**KIRKLEES METROPOLITAN COUNCIL
INVESTMENT & REGENERATION SERVICE**

DELEGATED DECISION TO DETERMINE PLANNING APPLICATIONS

Reference No:	2024/62/91130/W
Site Address:	33, Kingston Avenue, Dalton, Huddersfield, HD5 9HH
Description:	Erection of single storey side extension and associated alterations
Recommending Officer:	Joanna Rednall

DECISION – CONDITIONAL FULL PERMISSION

Proposed Elevations

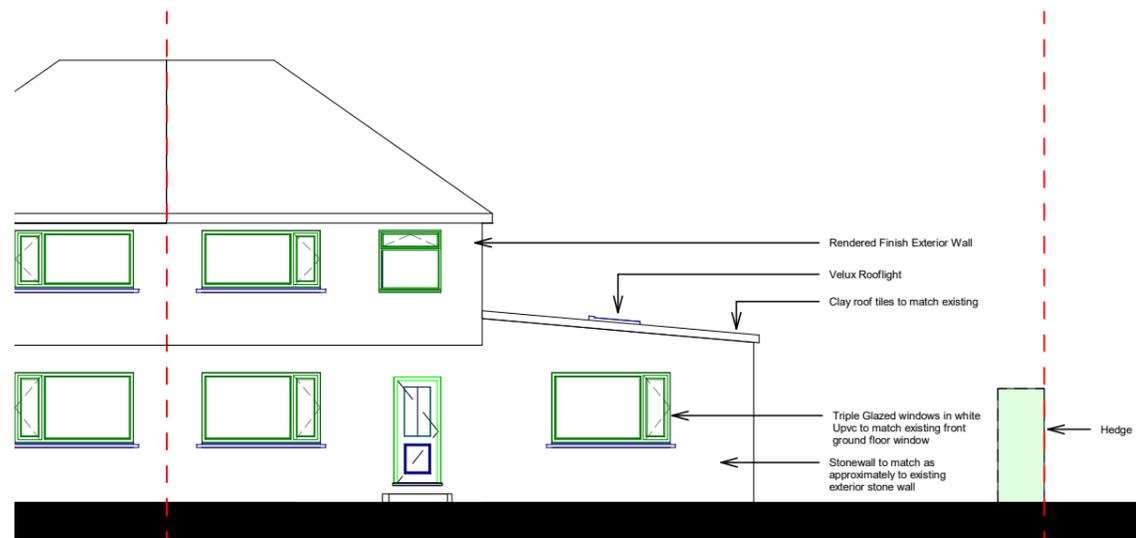
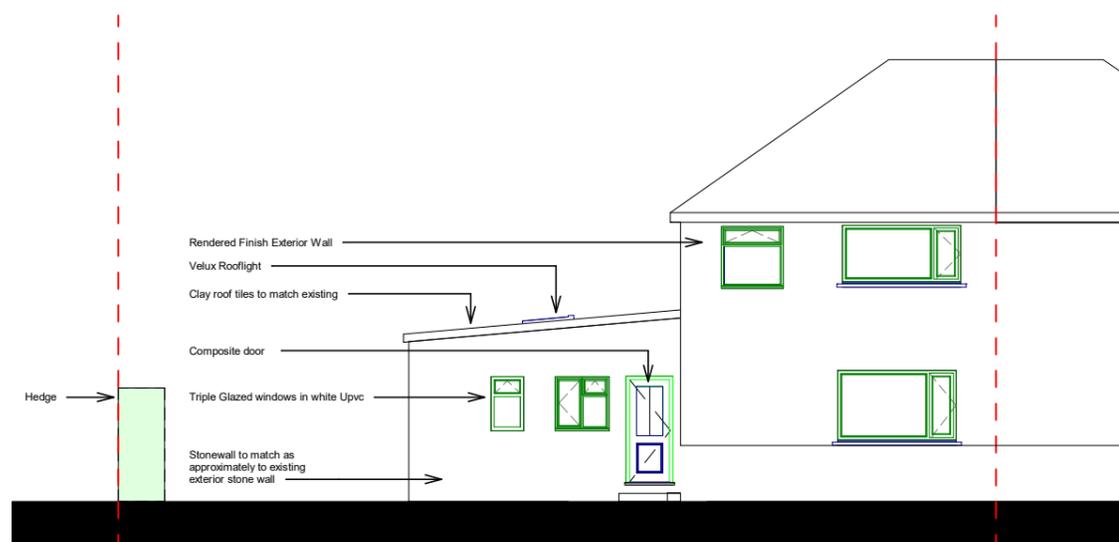
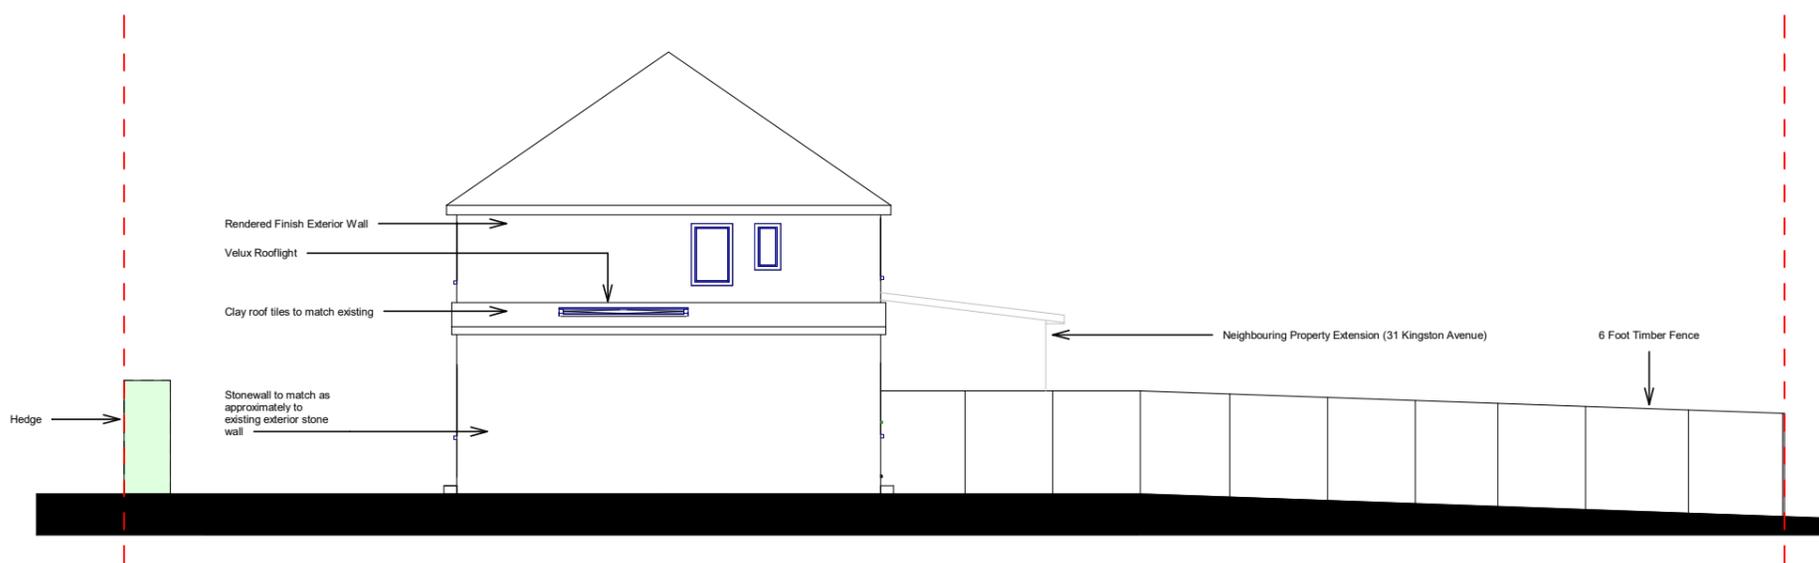
Contact was made with the applicant's agent requesting revised plans which reduce the scale and size of the proposal, with an amended roof design to

The extension is not set back and lies flush with the front elevation. This design is to allow an adequate internal entrance to the new bedroom. Although against SPD guidelines, the property is set well back from the pavement (approx. 6.5m) and a substantial amount of amenity space is retained to the front, side and rear of the property. As such, the scale of the proposed extension is considered to have an acceptable visual impact in this case. The proposed development would have the same fenestration and roof form to the host ensuring that details, form and scale are adequately respected.

The extension does not have any windows to the side elevation facing the highway (Staines Croft). However, the extension would face a high hedging boundary treatment and visually be of low impact. An acceptable level of garden space would be retained as a buffer between side boundary to mitigate any impact of the blank elevation to this street. The extension is set back from the existing building line on Staines Croft and the existing boundary treatments would be unaffected.

reflect the design of the host property. Amended plans were received 10th September, therefore these amended plans have been used in the determination of this application.

2. The external walls of the original dwelling shall be faced in cream or white render and retained thereafter.
